<b>Application Ref:</b>	3/2025/0160			 Ribble Valley Borough Council <a href="http://www.ribblevalley.gov.uk">www.ribblevalley.gov.uk</a>
<b>Date Inspected:</b>	N/A	<b>Site Notice:</b>	02/05/2025	
<b>Officer:</b>	MC			
<b>DELEGATED ITEM FILE REPORT:</b>				<b>REFUSAL</b>

<b>Development Description:</b>	Proposed demolition of existing holiday let chalet and replacement with one single-storey two-bedroom holiday-let. Alterations to existing access and with replacement entrance gates and pillars.
<b>Site Address/Location:</b>	Hazelmere, Longridge Road, Hurst Green, BB7 9QP

DRAWING TITLE:
Entrance Elevation

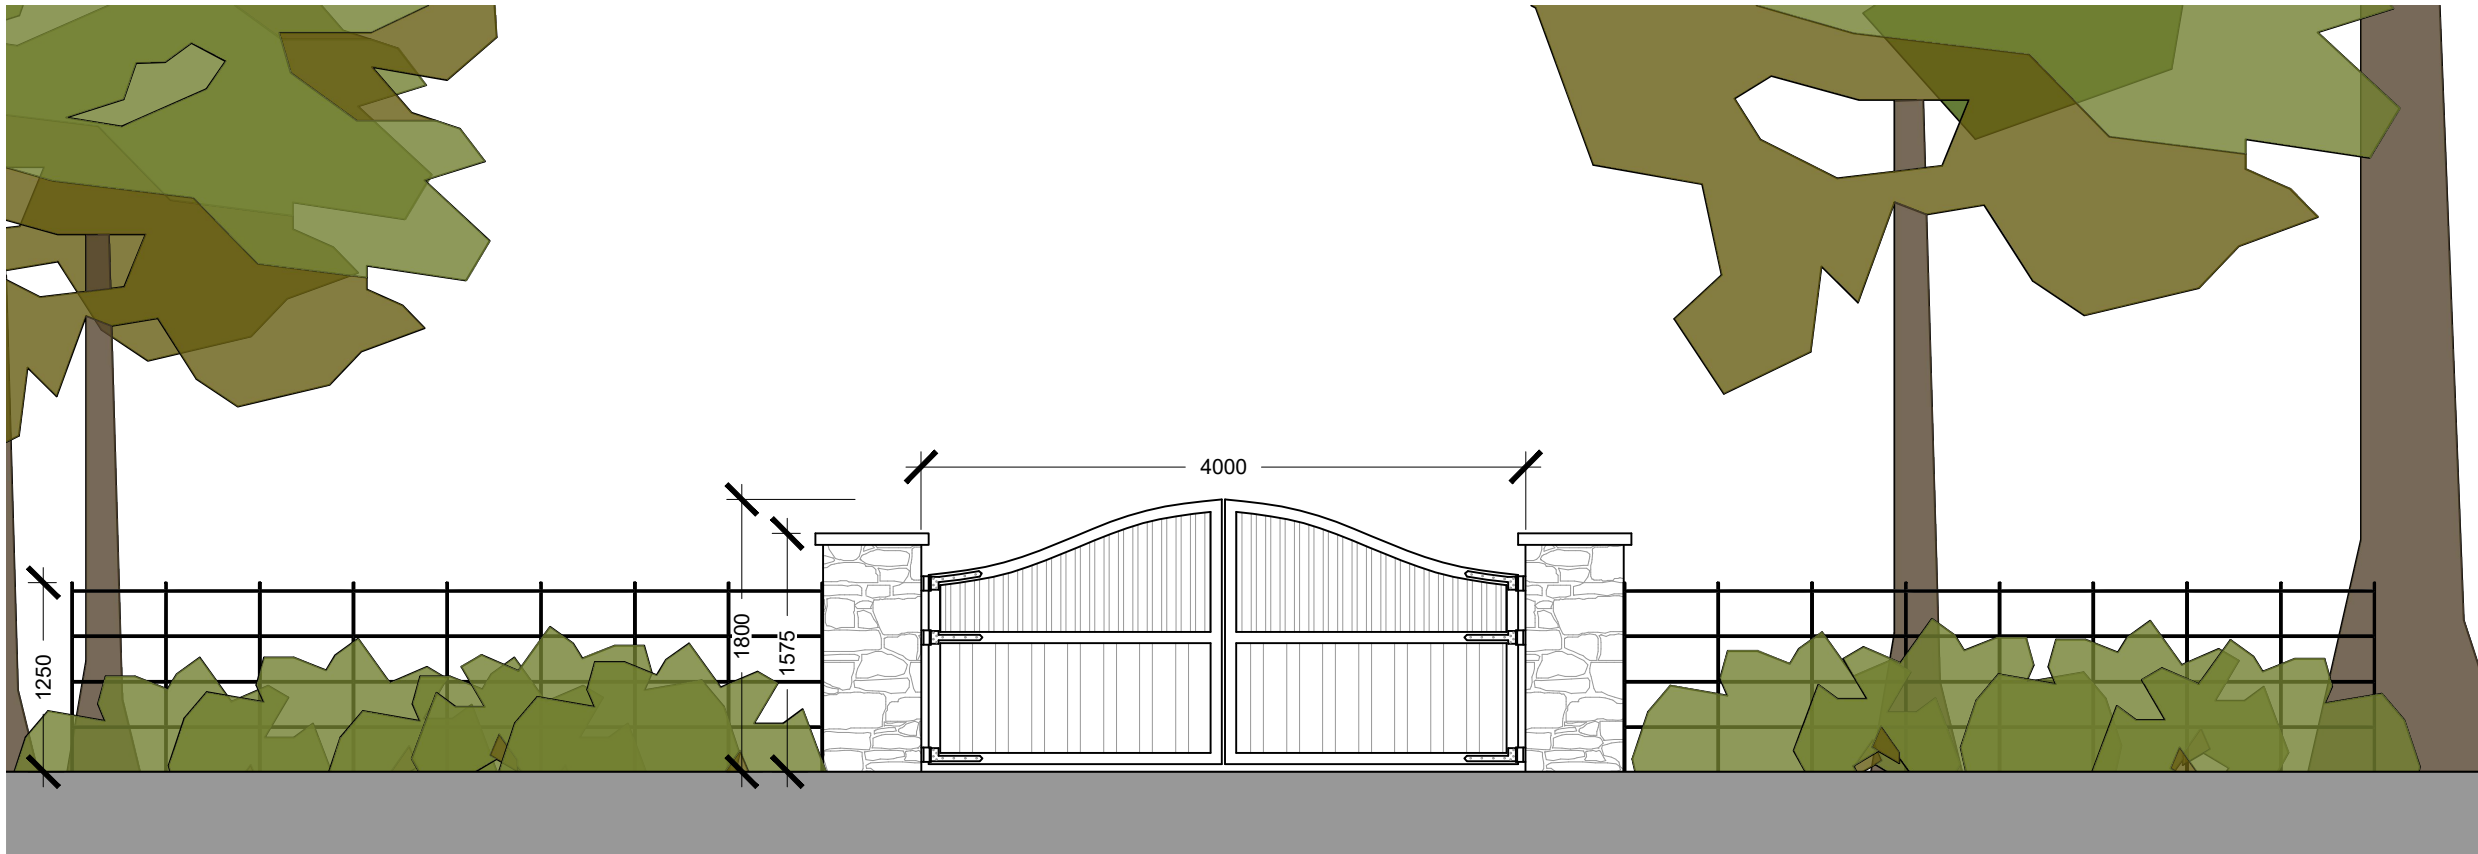
The proposal would include the demolition of the existing gates and erection of new entrance gates. These would be taller than the existing gates, and their solid design together with the proposed brick pillars would give the site a more domestic and urban appearance as seen from the road. In addition, the new area of hardstanding created for the proposed parking/turning area is considered to be fairly large and would also have an urbanising effect on the Forest of Bowland National Landscape. No amendments have been made from the previously refused scheme in terms of the level of hardstanding and the design of the brick pillars and entrance gates.

The Highway Authority have been consulted on the application and they consider that having undertaken a site visit, the visibility splays are severely substandard and currently would present a highway safety concern. They LHA still consider that the vegetation along the frontage of the site on Longridge Road can be removed/scraped back/reduced in height to improve the splays and therefore a visibility splay drawing should be submitted to demonstrate the maximum available splays at the access and the mitigation measures which are proposed. They consider that the proposal to realign and widen the site access is considered necessary and whilst the width of the access at 4m and the setback from the highway is considered acceptable, they consider that the proposal would intensify the use of the access and consider it necessary to improve the visibility splays for highway safety reasons.

The LPA consider that whilst the proposal would not now be for a change of use, given the substandard existing vehicular access and creation of a significant area of hardstanding, the proposed development would result in an intensification of the use and existing level of vehicular movements. As such, without sufficient visibility splays being provided, this would have a significant impact on highway safety, contrary to Policy DMG1 of the Ribble Valley Core Strategy.

DRAWING TITLE:  
 Proposed Elevations

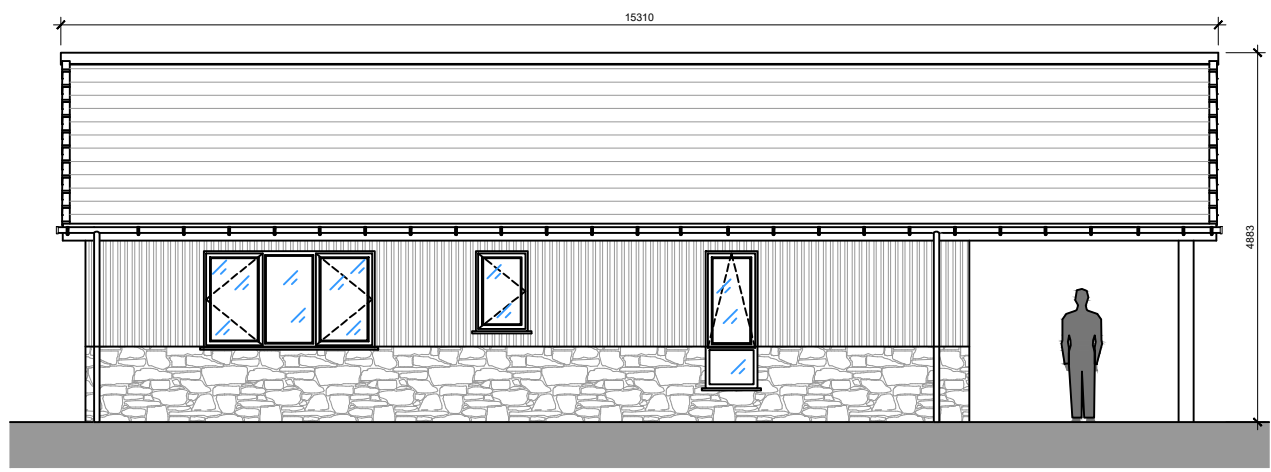
The size, siting and design of the holiday let is mostly the same as the refused scheme, however the glazing to the south elevation has been set in from the gable. A pitched roof canopy has also been added to the side elevation. Previous concerns were raised regarding the amount of glazing to the front elevation and the modern appearance being incongruous to the rural setting, when compared to the simple design of the wooden holiday let chalet. It was also previously noted that some vegetation would have to be removed to achieve appropriate visibility splays and concerns were raised regarding the increase in land levels from the road level which would increase visibility. Furthermore, it was not considered that the proposed roof which would be constructed of standing seam has been sensitively designed to conserve the character of the Forest of Bowland National Landscape.

Whilst the level of glazing has been reduced when compared to the refused scheme and there may be less domestic paraphernalia associated with a holiday let when compared to the dwelling, it is not considered that the previous reasons for refusal have been overcome. The proposal would still include a large area of hard surfacing to the front of the site, new entrance gates/walls which are domestic in appearance and inappropriate external materials to the roof of the holiday let. In isolation, the design of the building (other than the roof materials) could be considered acceptable, cumulatively, the proposal would fail to protect or conserve the character of the Forest of Bowland National Landscape and would introduce an unsympathetic and incongruous form of development to the rural area, contrary to Key Statement EN2 and Policies DMG1 and DMG2 of the Ribble Valley Core Strategy.

DRAWING TITLE:
 Proposed Refuse Plan

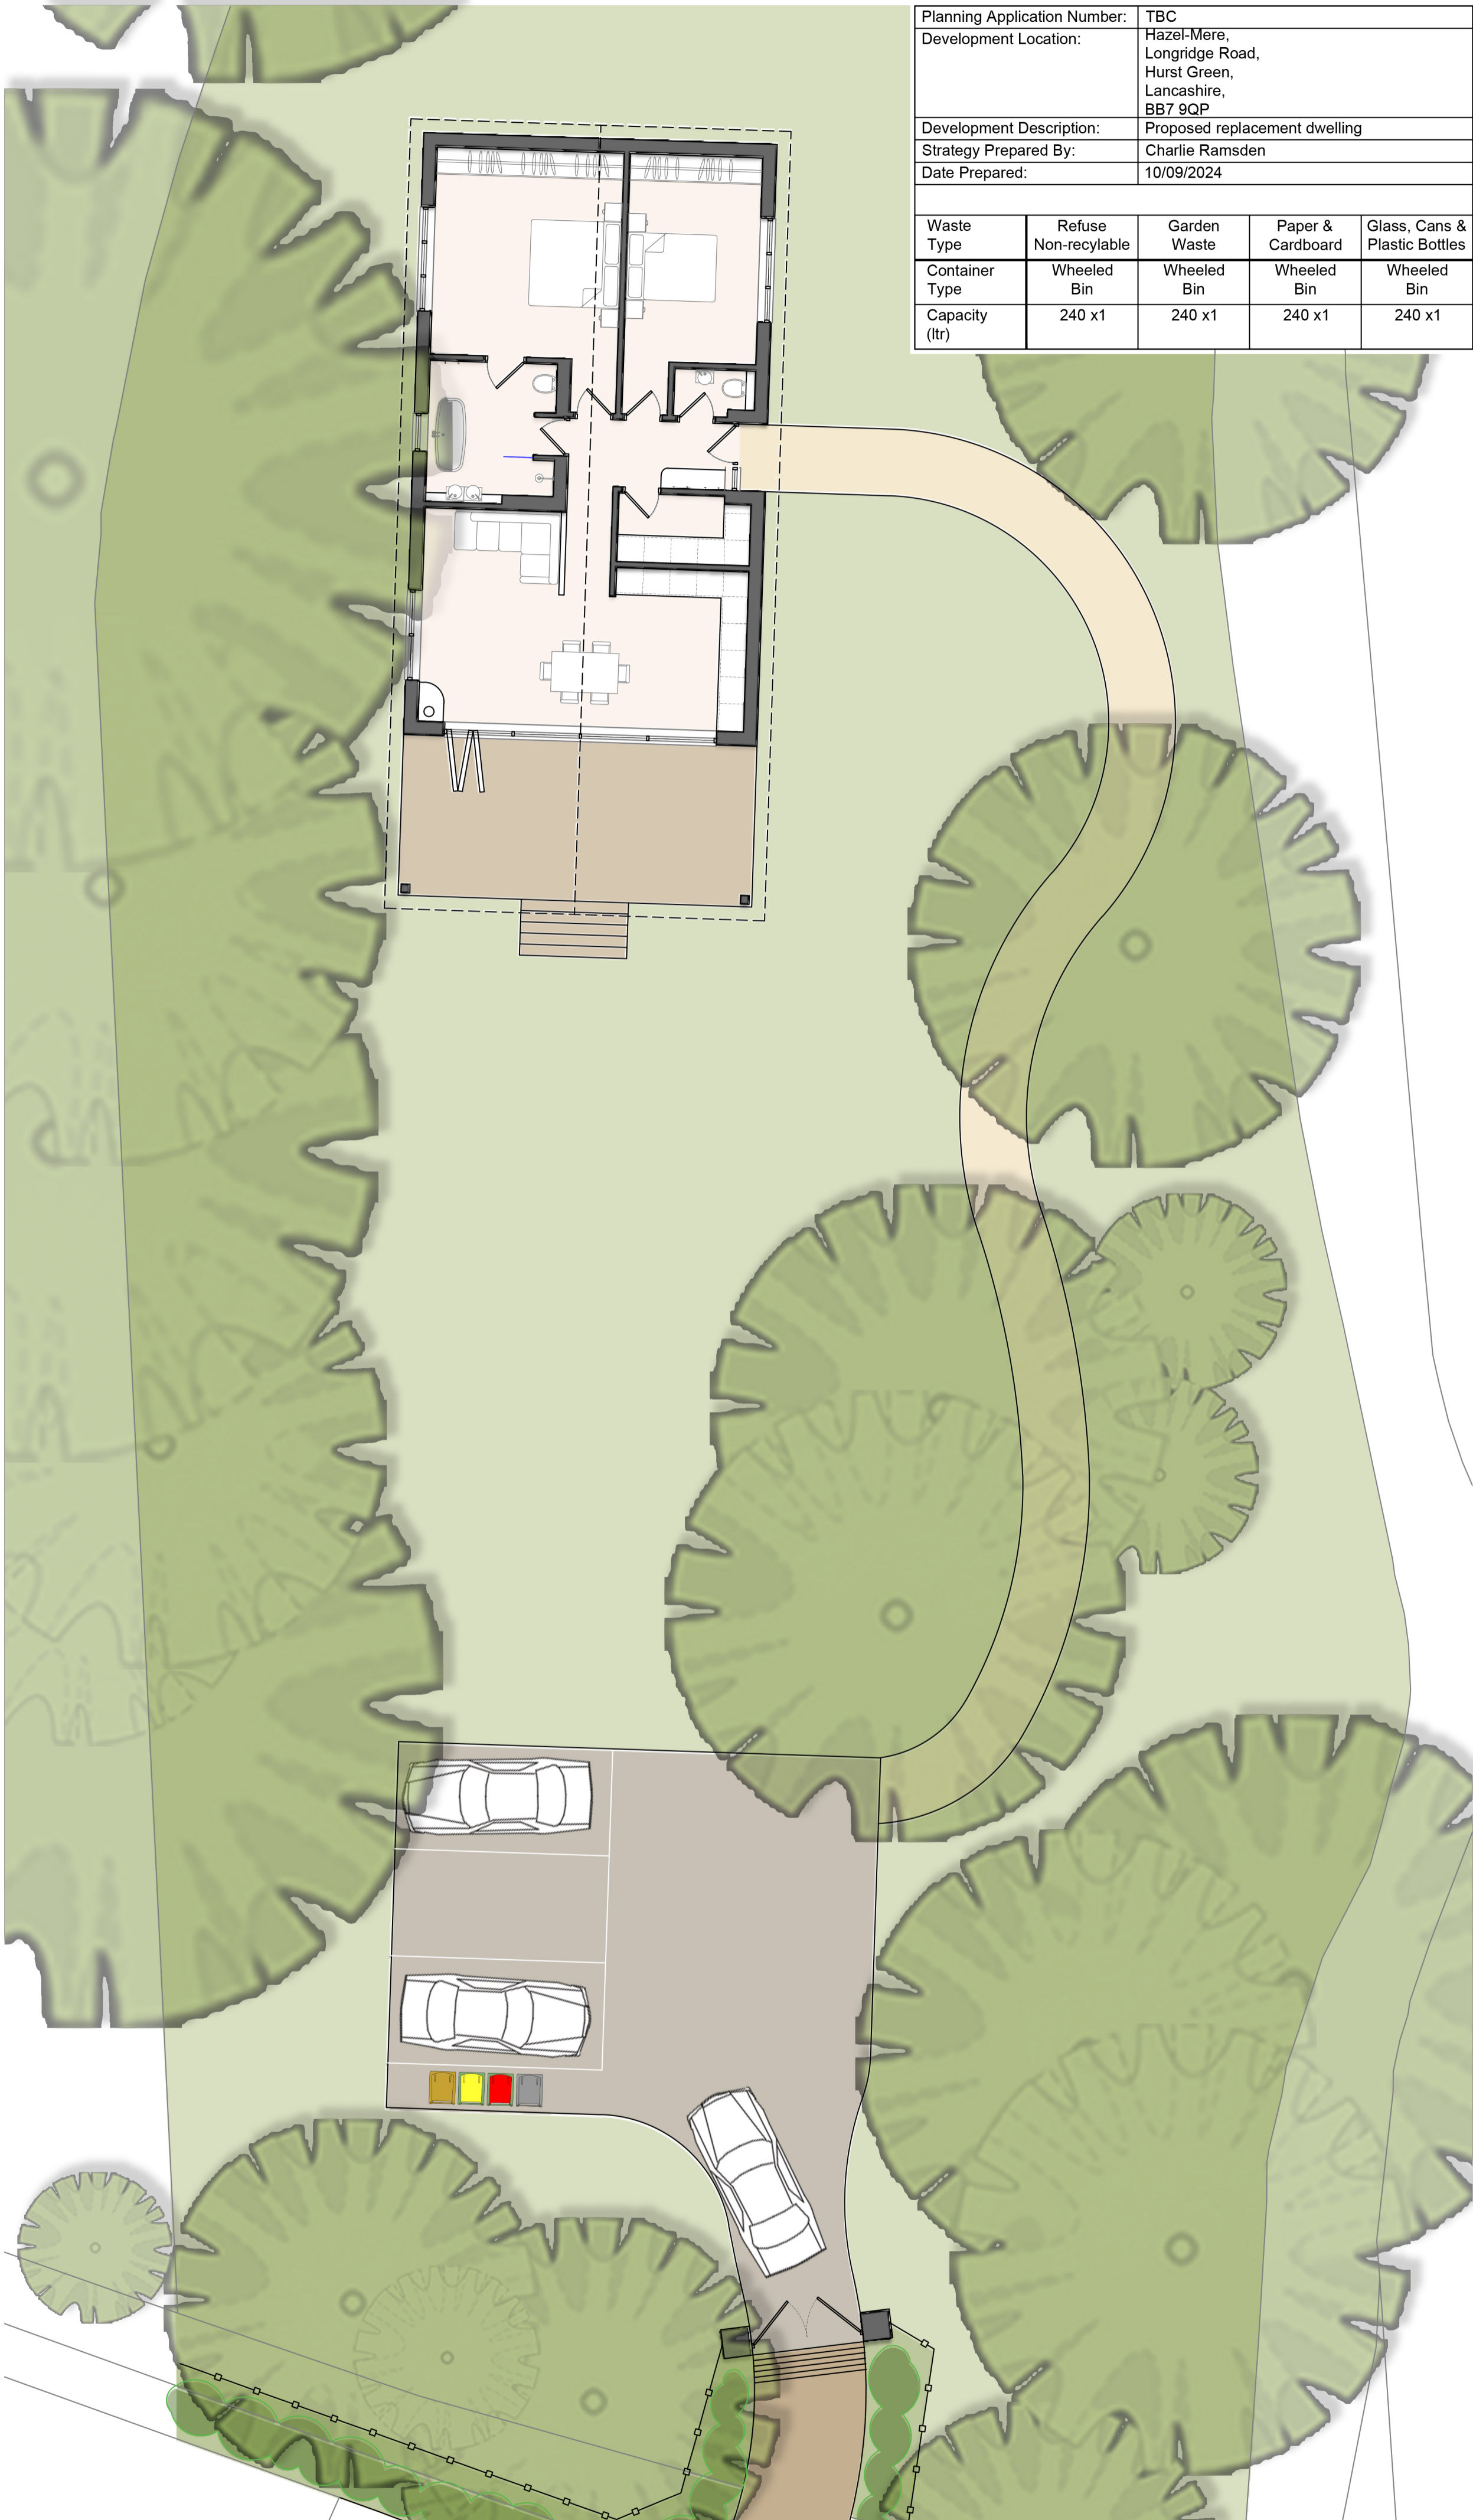
The proposal also includes the creation of a new large parking area to the front of the site as well as new entrance gates, stone pillars and fencing which would have a total height of between 1.25 metres, extending up to 1.8 metres at the highest point of the entrance gates. A car parking area is also proposed to the front of the site to provide bin storage and car parking for 3 no. vehicles as indicated on the proposed refuse plan.
